Please ask for: Mrs D Johnson
Email: daun.johnson@arun.gov.uk
Telephone: 01903 737762
Our Ref: M/92/21/PL
Your Ref:
Date: 6th July 2021

Application for Planning Permission

Development: Demolition of existing bungalow & construction of 1 No 2-storey dwelling with access & off road parking. This site is in CIL Zone 4 & is CIL Liable as new dwelling.

Location: 68 Ancton Way Elmer Middleton-On-Sea PO22 6JP

PROPOSED PLOT PLAN

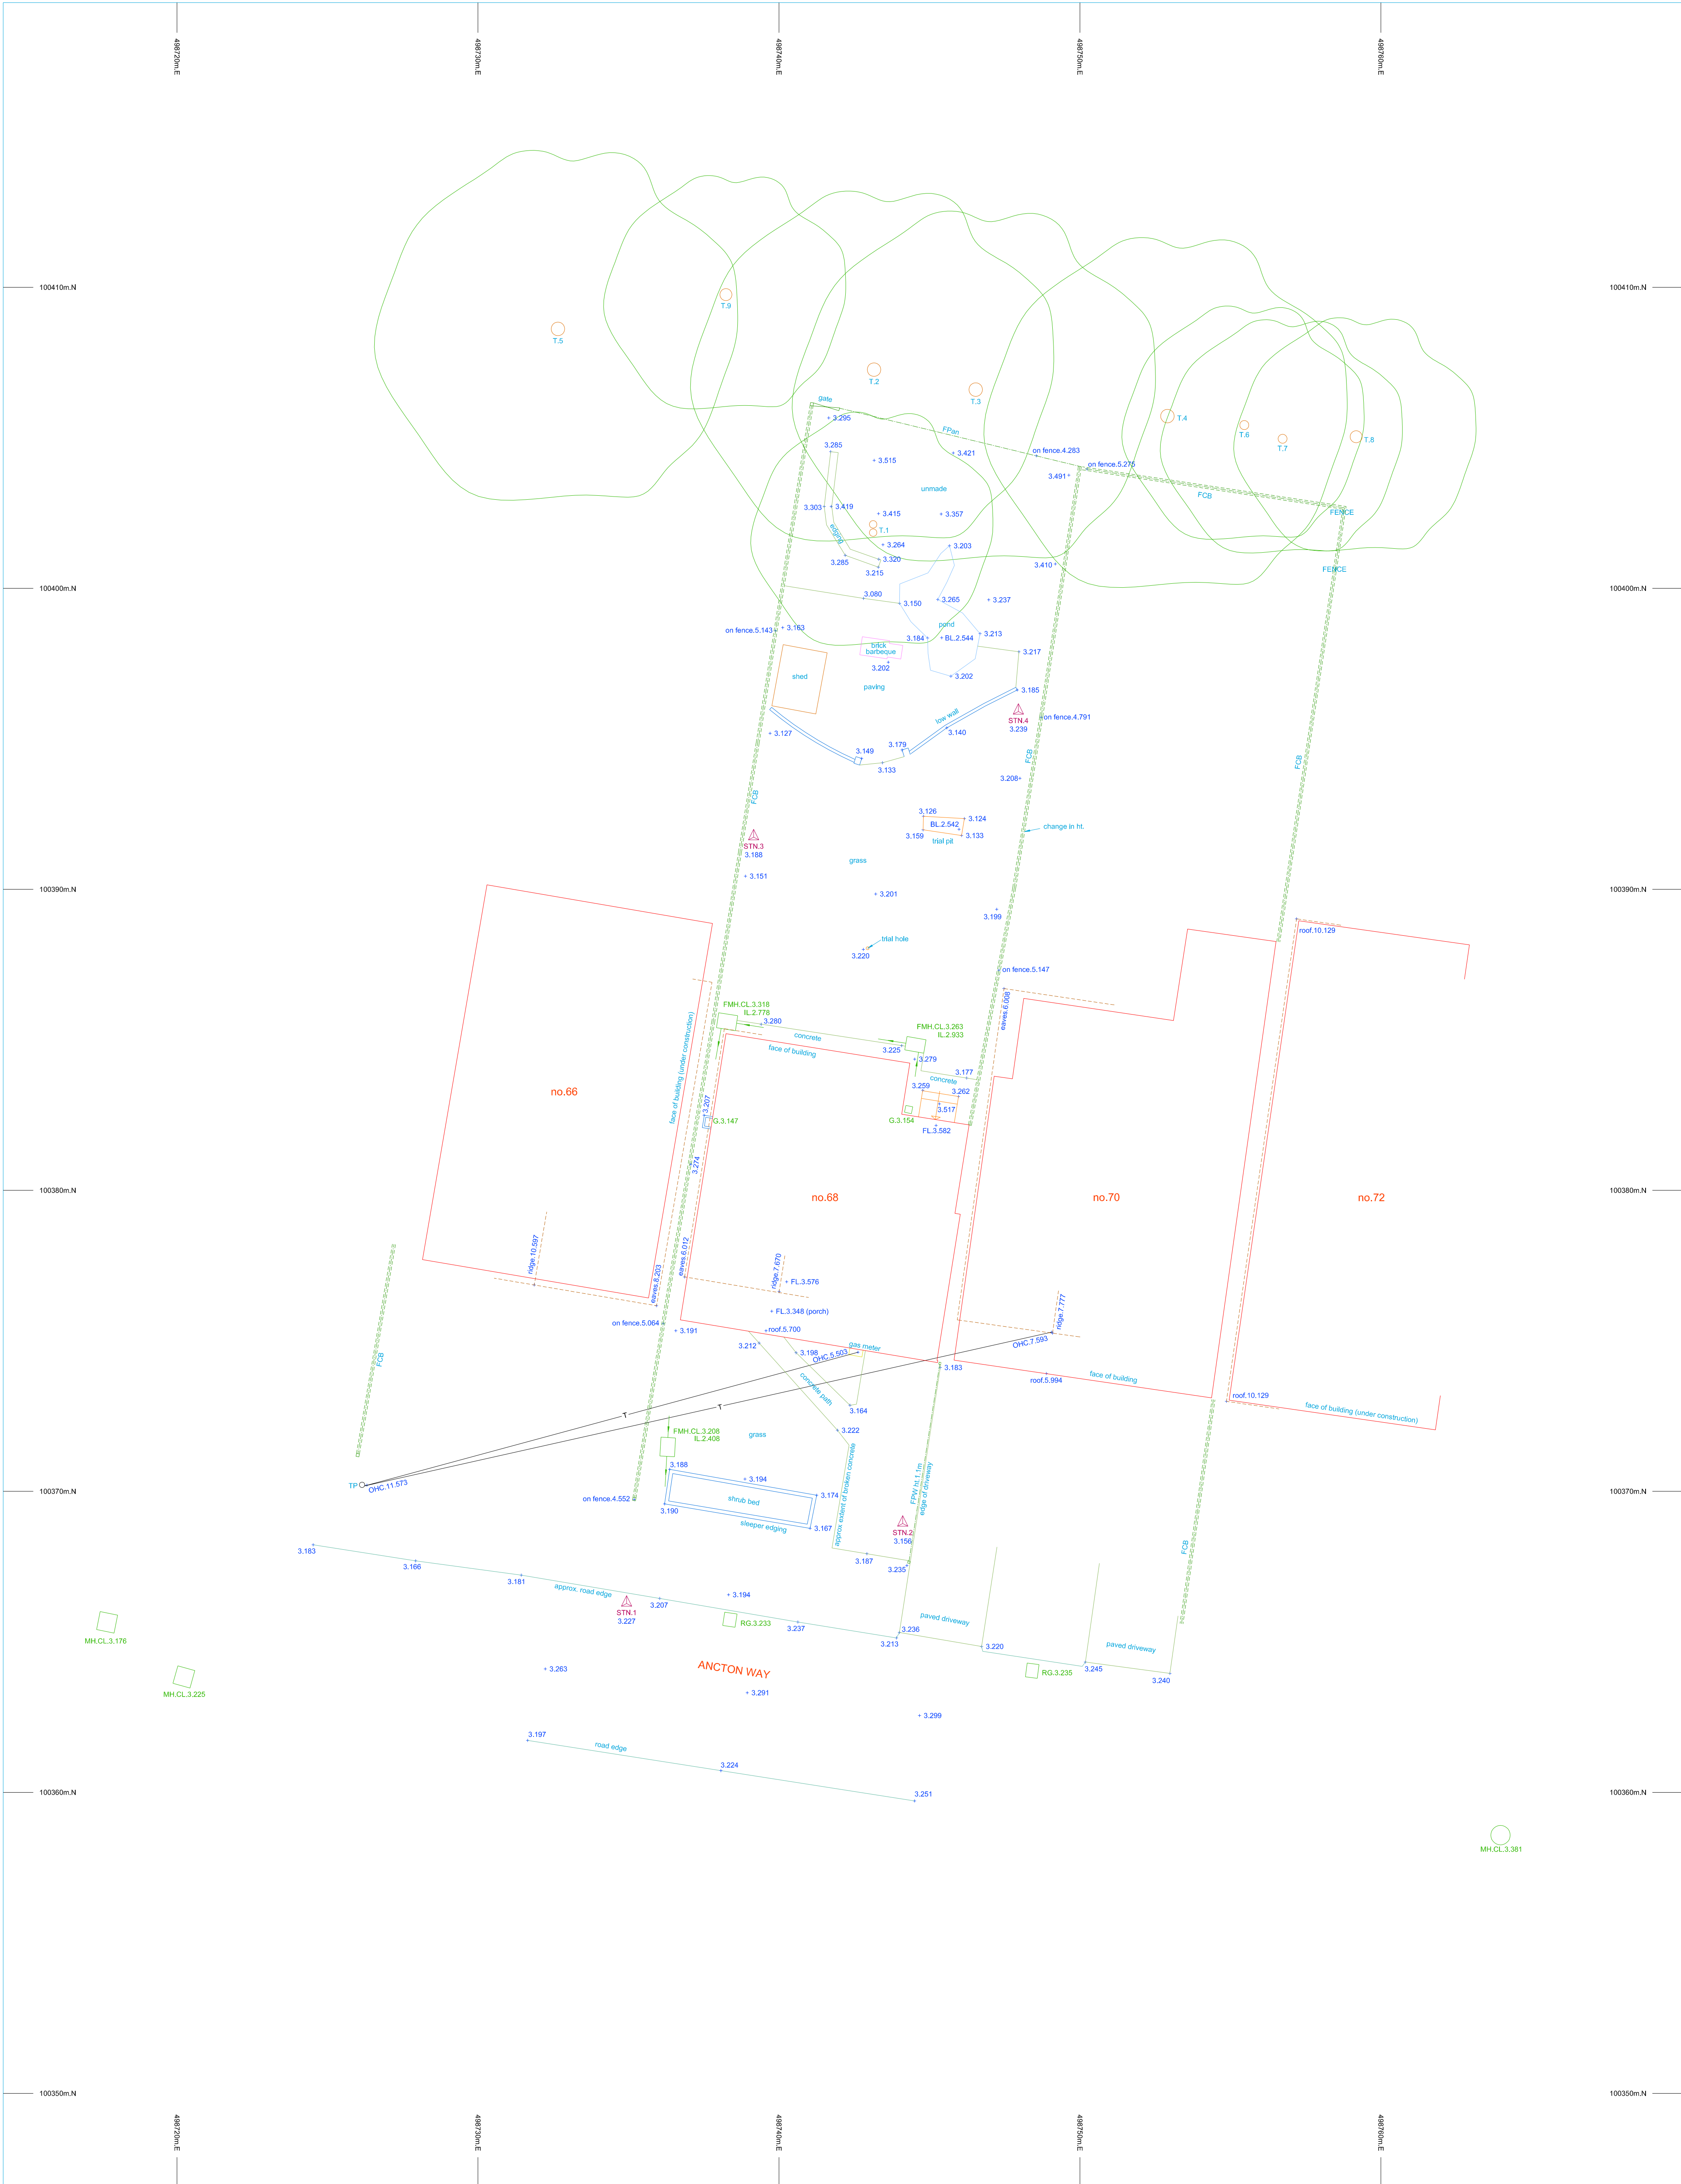
Please re-label one of the proposed plot plans as existing.
